**KIRKLEES METROPOLITAN COUNCIL
INVESTMENT & REGENERATION SERVICE**

**DELEGATED DECISION TO DETERMINE APPLICATIONS FOR
CONSENT, AGREEMENT OR APPROVAL REQUIRED BY CONDITION**

Reference No:	2025/44/90350/W
Site Address:	Southgate/Leeds Road, Huddersfield, HD1 1TW
Description:	Discharge of conditions 2 (materials (brick)), 3 (materials (other)) and 4 (anti-terrorism mitigation) of previous Reserved Matters approval 2023/93655 pursuant to (Phase 2 of) outline permission 2021/91544 for erection of health and research innovation campus comprising: Class F1(a)-education; Class E(e)-medical/health services; Class E(g)(i)-offices; Class E(g)(ii)-research/development of products/processes; multi storey car park; Class E(a)-display/retail of goods; Class E(b)-sale of food/drink; Class E(d)-indoor sport/recreation/fitness and the discharge of conditions 5 (masterplan), 6 (design code), 9 (internal access per phase) and 19 (BEMP per phase)
Recommending Officer:	Victor Grayson

Discharge of conditions 2 (materials (brick)), 3 (materials (other)) and 4 (anti-terrorism mitigation) of previous Reserved Matters approval 2023/93655 pursuant to (Phase 2 of) outline permission 2021/91544 for erection

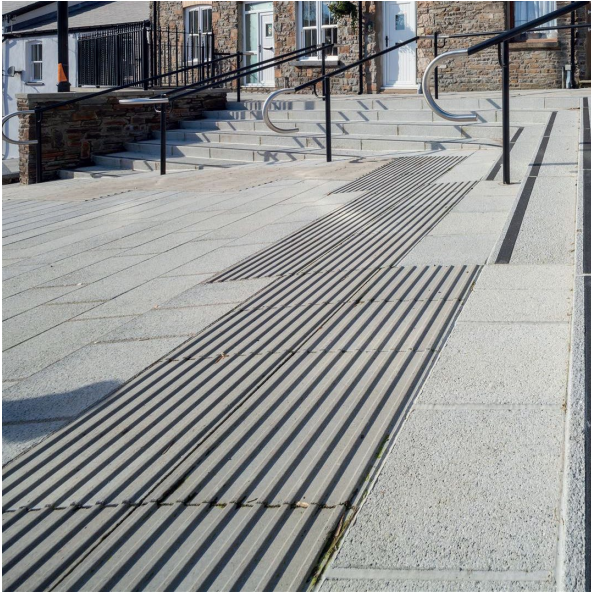
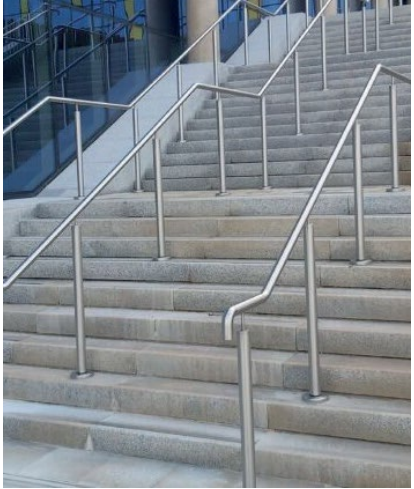
For the main block, the choice of mortar colour was the subject of extensive discussion. The “Portland” mortar (from the Parex Historic KL range by Sika) initially proposed by the applicant team was considered too bright. A sample panel of that mortar was viewed on site on 21/02/2025 and 17/04/2025. The mortar now proposed by the applicant team is a 50% / 50% mix of the “Portland” and “Sandstone” mortar colours from the same Parex Historic KL range. A sample panel of that mortar was viewed on site on 22/05/2025 – officers noted that this mortar would be less bright, and would be more reflective of the mortar and stone of the historic buildings within the town centre (as well as the less bright materials of more recent nearby buildings). The proposed 50% / 50% mix of the “Portland” and “Sandstone” mortar colours is considered acceptable.

Mortar joints would be concave (recessed), which is considered acceptable.

The submitted documents detail an appropriate stretcher bond pattern for the majority of the elevations, with some inset areas of stack bond and soldier coursing (in the same brick) to add visual interest. Some soldier coursing has been deleted at the corners of the main block between second and third floor levels, which is considered acceptable – this detailing was not an essential element of the elevations needed to make the block acceptable in design terms.

Details set out in the above-listed documents are considered acceptable for the purpose of condition 2, and are hereby approved.
